**Documents Related to 4.201 [Major New Domestic Water/Wastewater]**

## Documents Related to 4.201 [Major New Domestic Water/Wastewater]

WATER TREATMENT PLANT

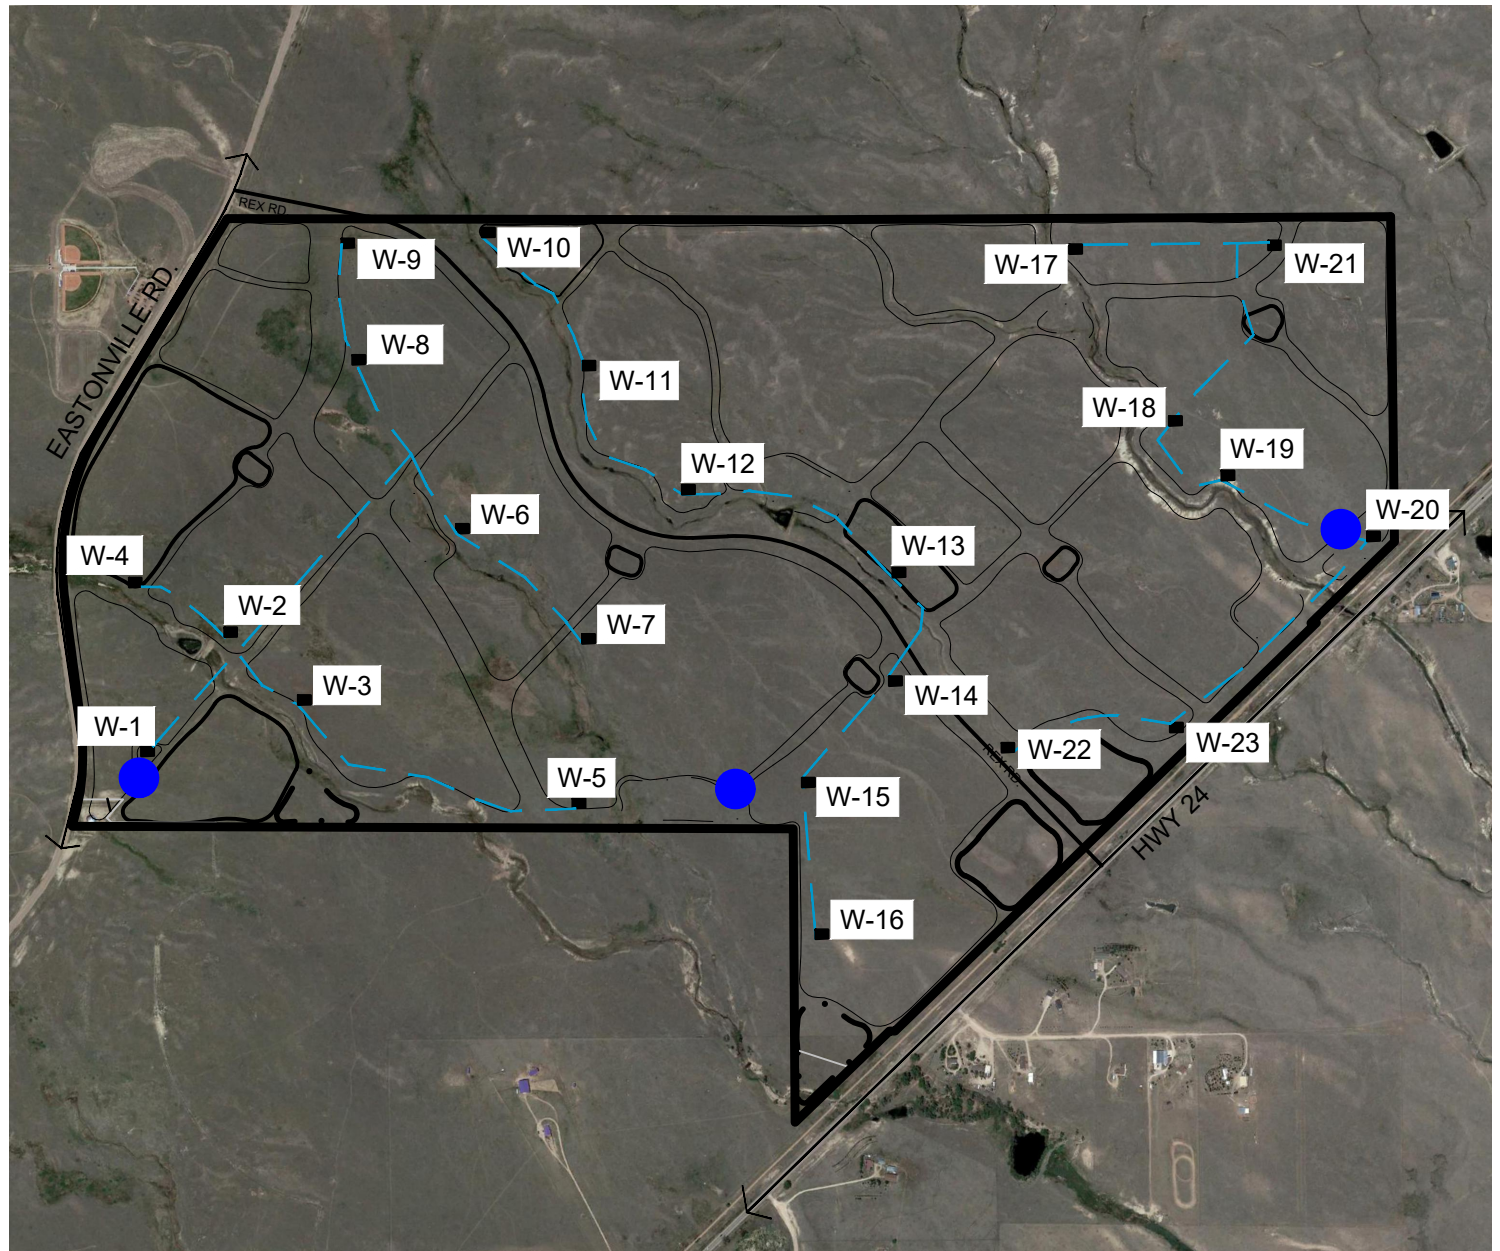
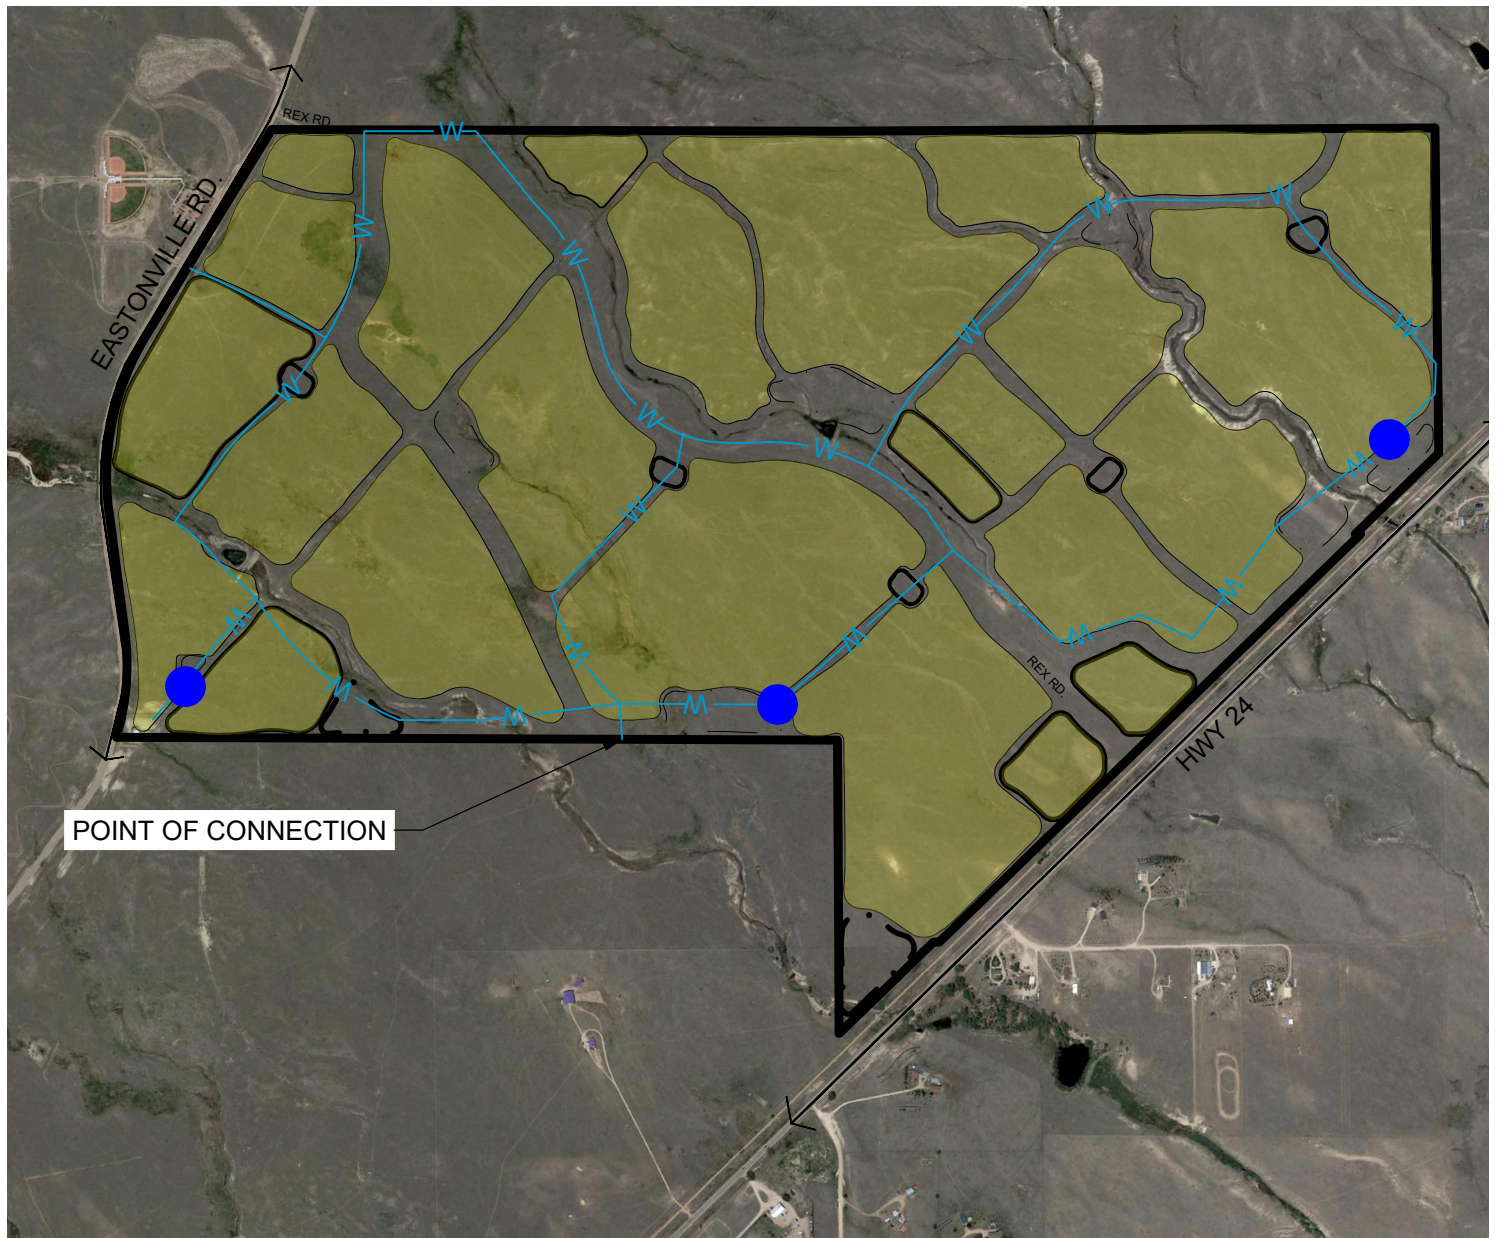
please provide the details on the water and sewer maps.

tank sites? How many, how large, what kind of material, above or below ground? YOU have to tell us now so you dont have to amend the 1041 later- Over estimate if needed on ALL infrastructure

METRO DISTRICT BOUNDARY

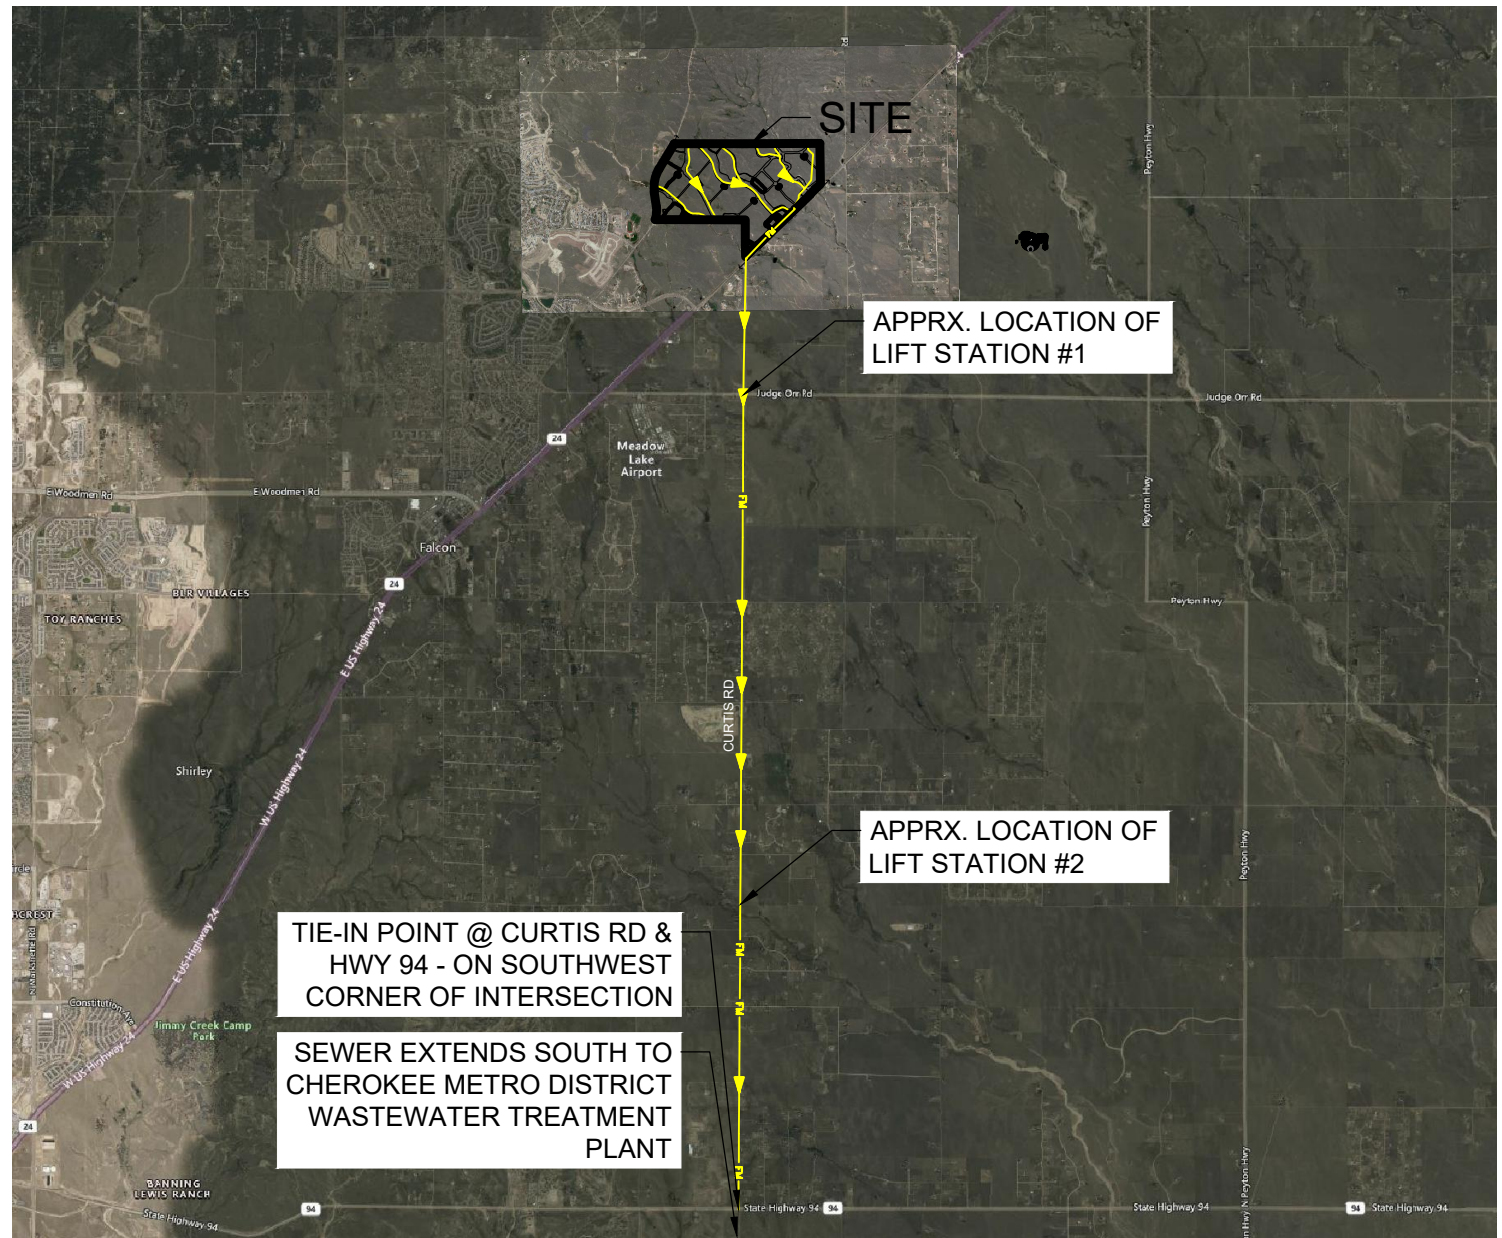
hoe many, how large, what flows? same with pump stations, treatment facilities.
